Tel: 01903 737756
Email: planning@arun.gov.uk
www.arun.gov.uk/planning
Please ask for: Jonny Cooper
Email: jonny.cooper@arun.gov.uk
Telephone: 01903 737532
Our Ref: BR/172/25/PL
Your Ref:
Date: 8th October 2025

Application for Planning Permission

Development: Replacement of existing pitched roof with a mansard type roof over Block A outbuilding of Belmont Lodge.
Location: Belmont Lodge Belmont Street Bognor Regis PO21 1LE

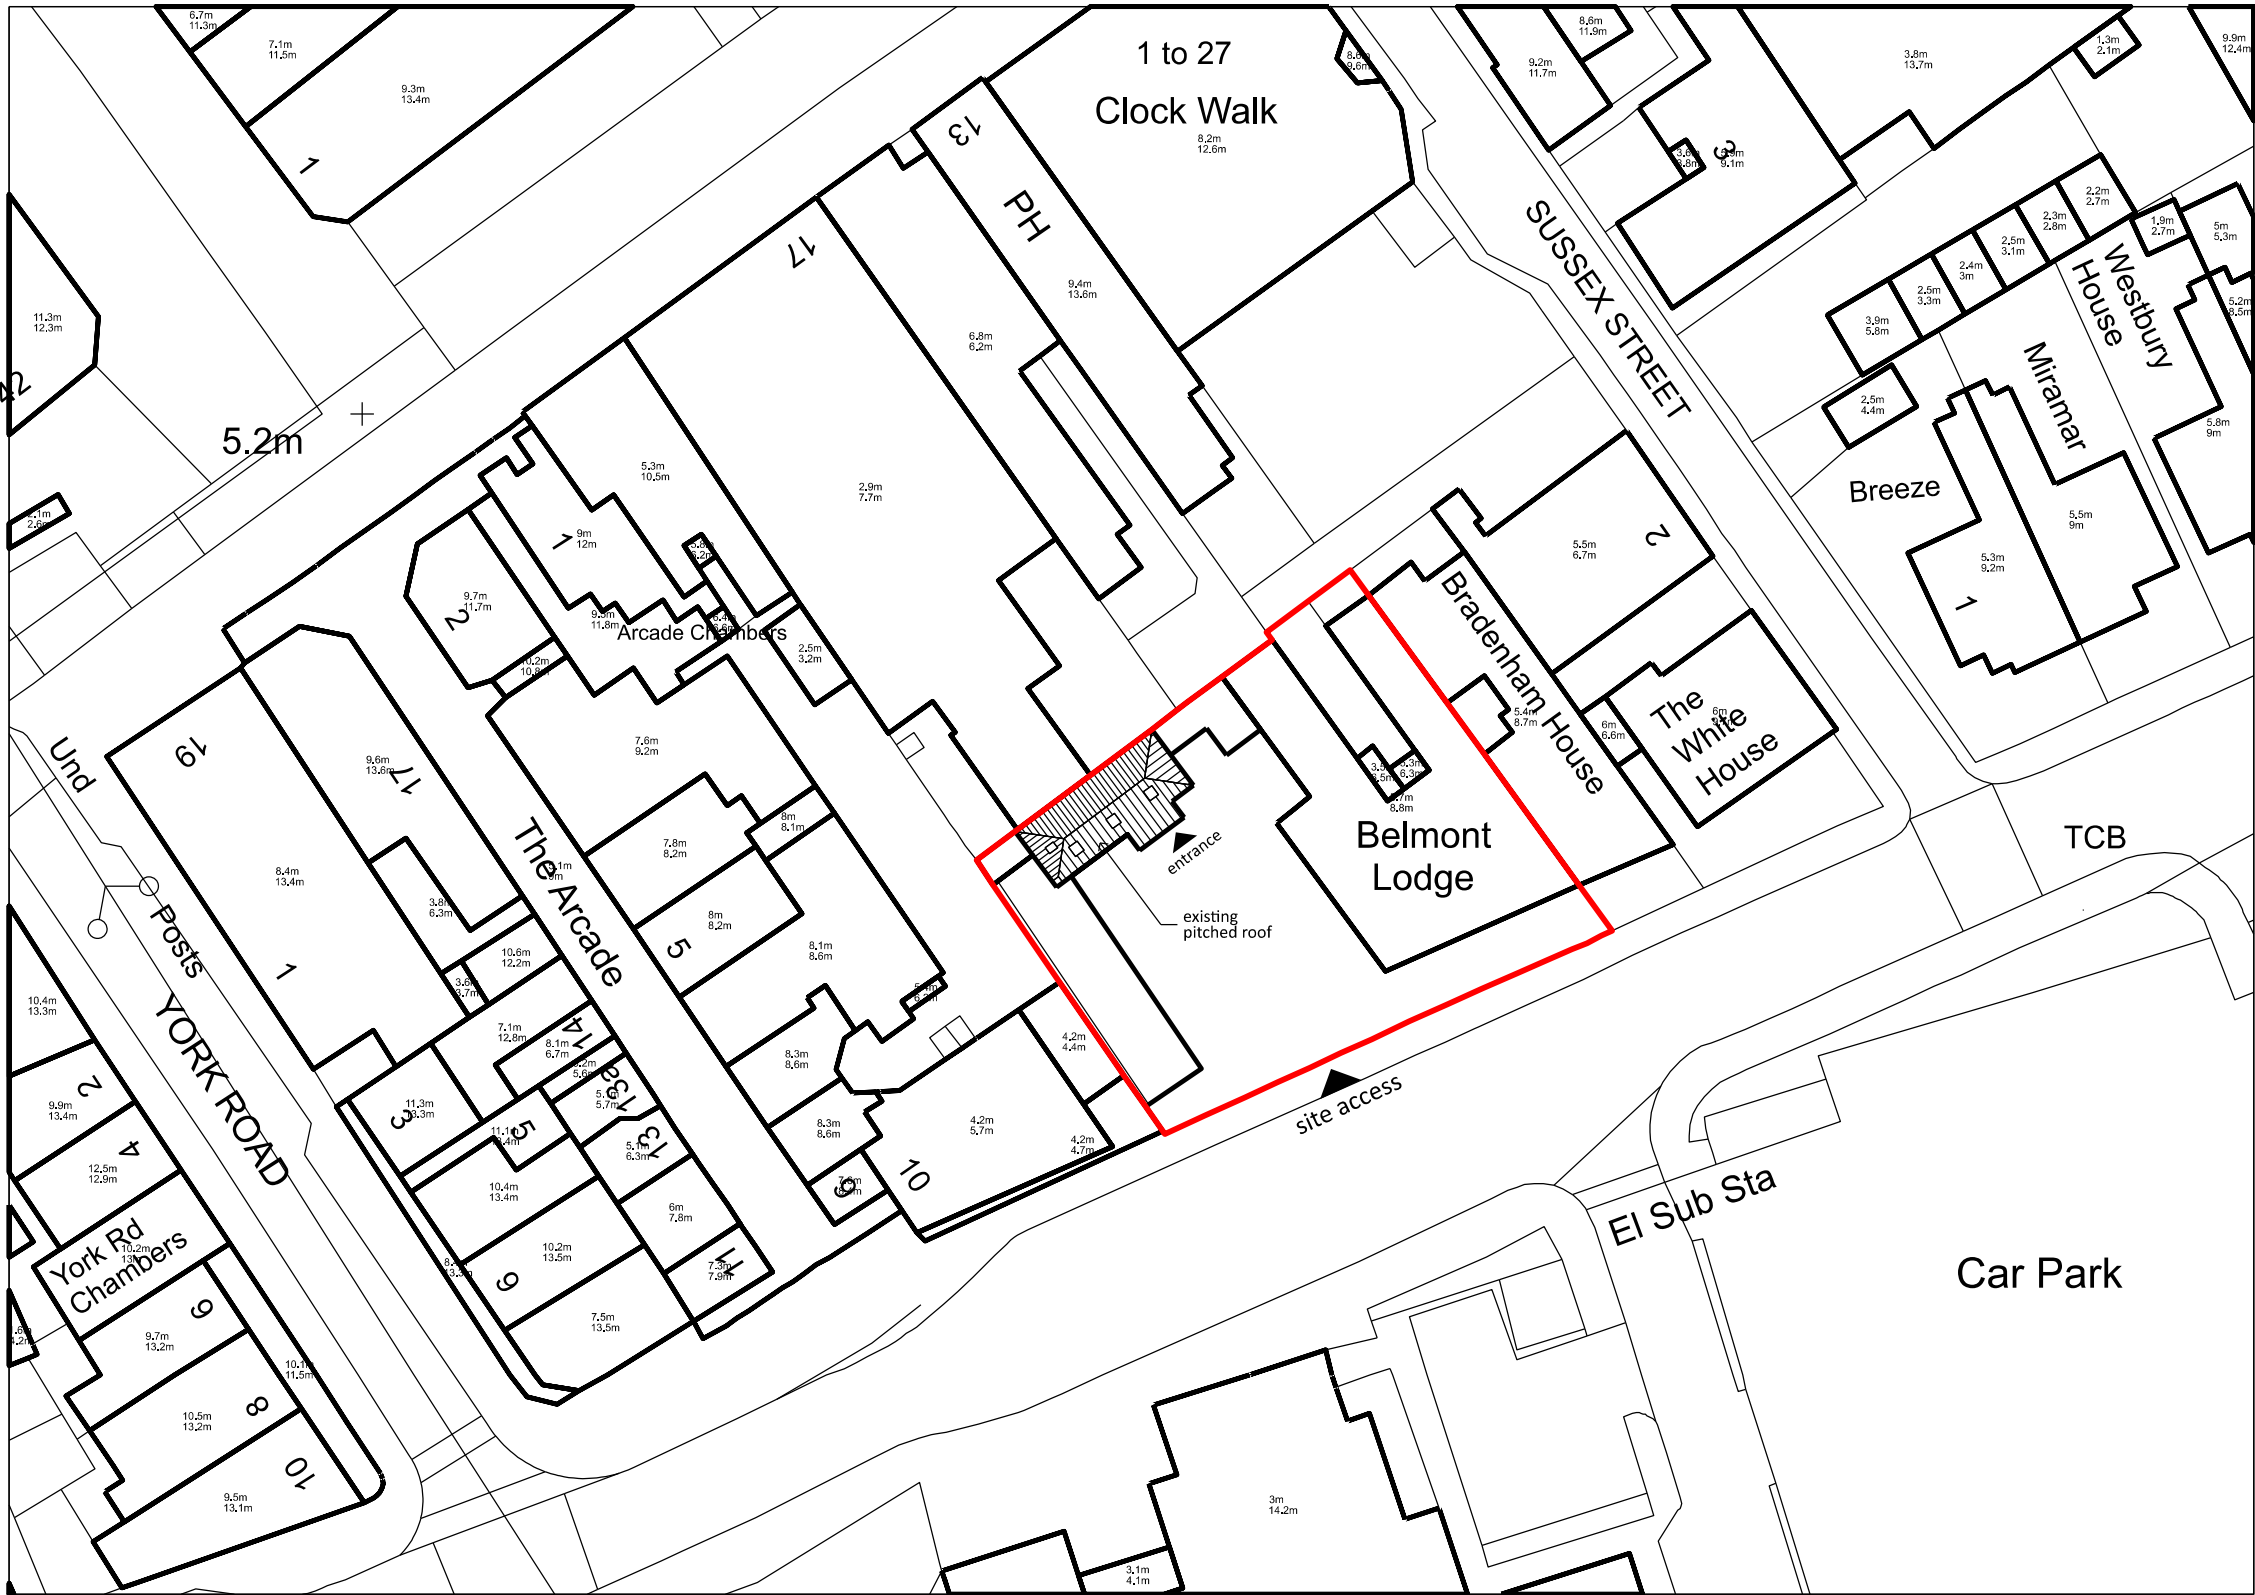
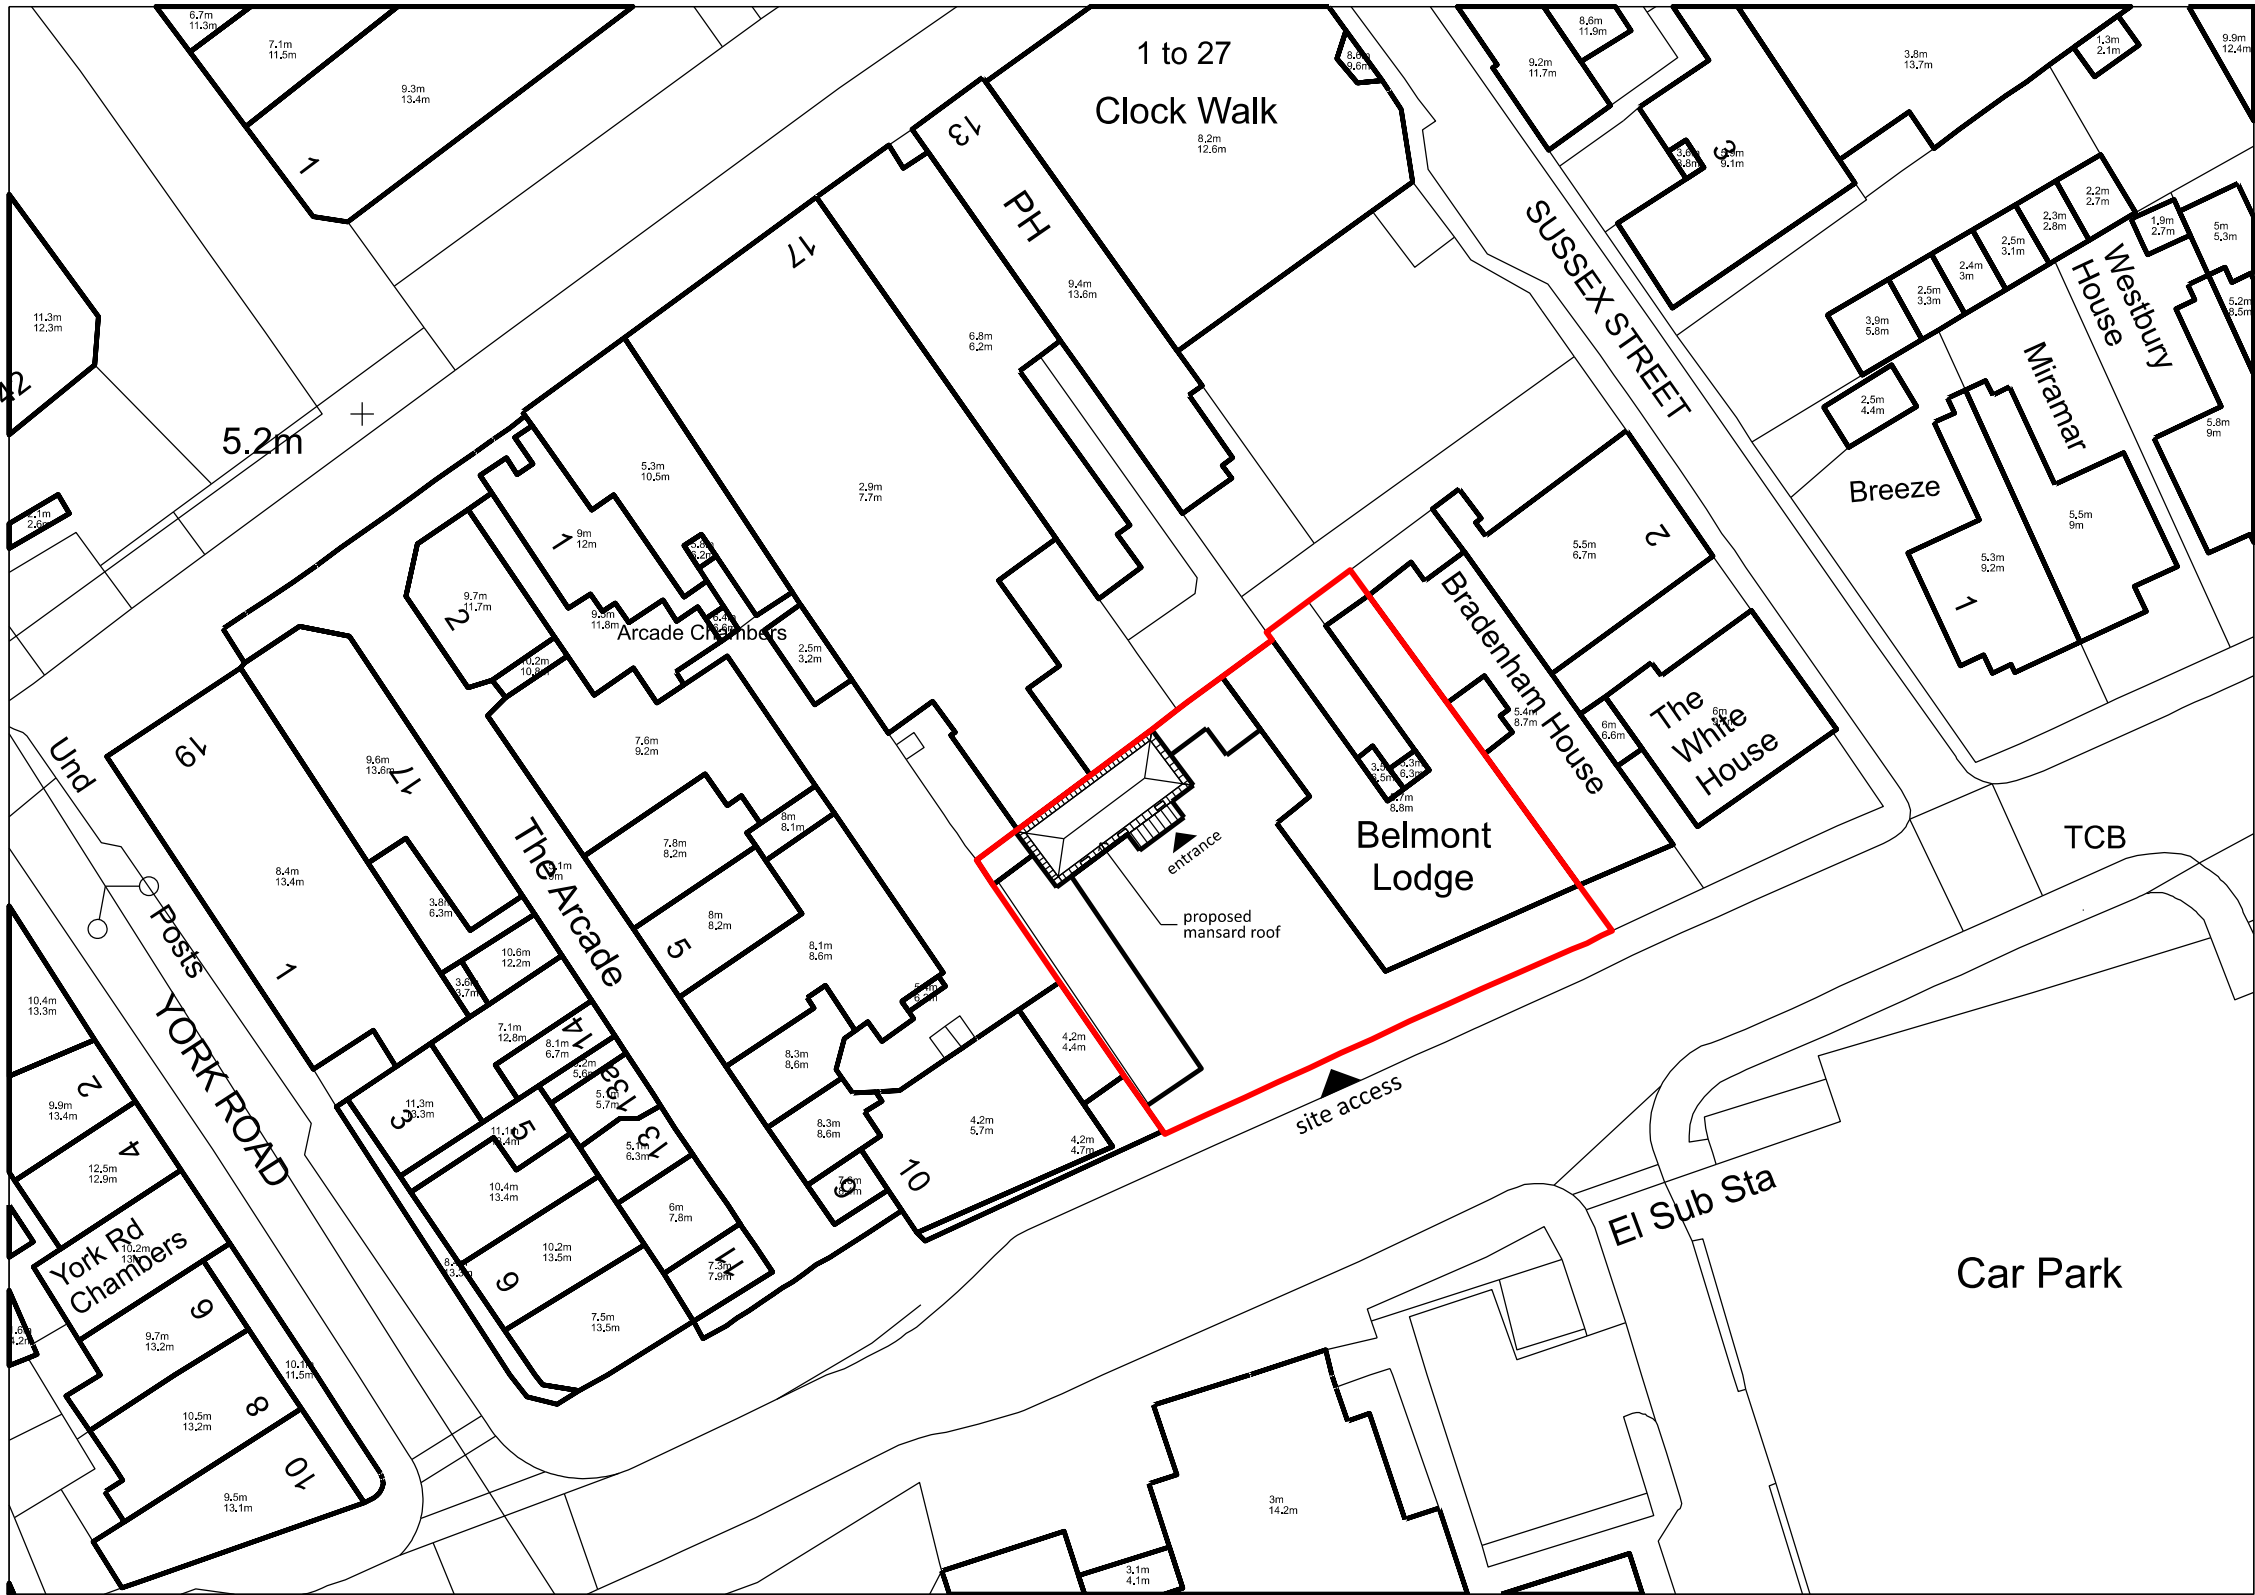
Site Plans

The scale bars on the existing and proposed site plans do not scale correctly. Please amend accordingly and resubmit.
